Planning Services Sign Permit Review Form

Date of Submittal	Application Number	Applicant	Landowner
4/26/2023/	SIGN2304-0004	Weller Developers	Wellers Knoll HOA Inc.

Contact Person	Braxton Montague	Contact Number	919-669-6893
Sign Location	At the intersection of McDougald Rd. and Old Charred Oak Ct., and McDougald Rd. and Old Fashion Way	PIN Number	0529-89-1139.000

Entry Statement
OPT A (V-Carved)
Double Sided

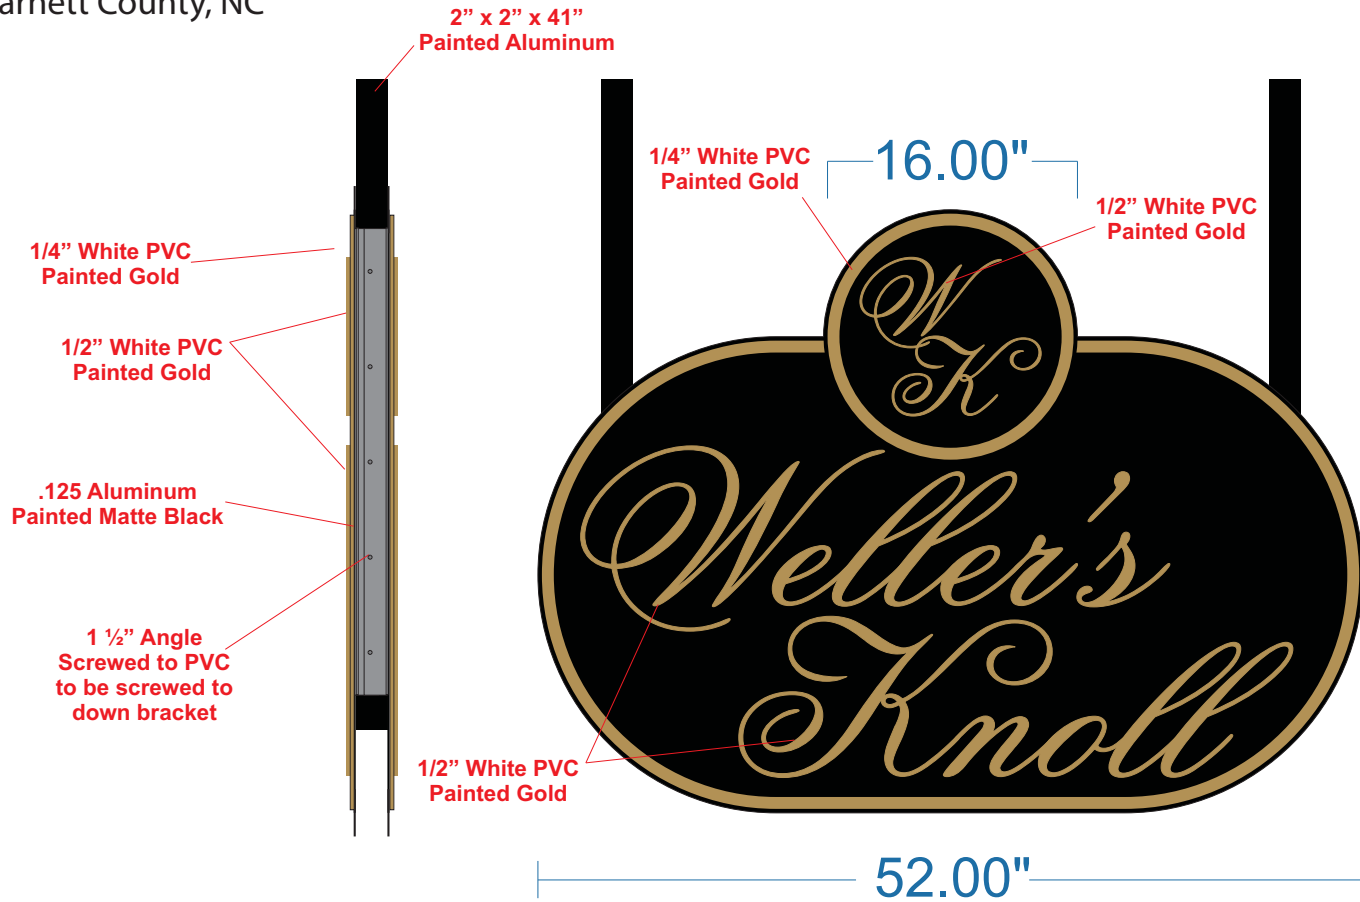
Comments	The square footage exceeds the permitted 50 square feet permitted. The square footage is 60 square feet. The signage is calculated by measuring the smallest parallelogram around the sign.
----------	---
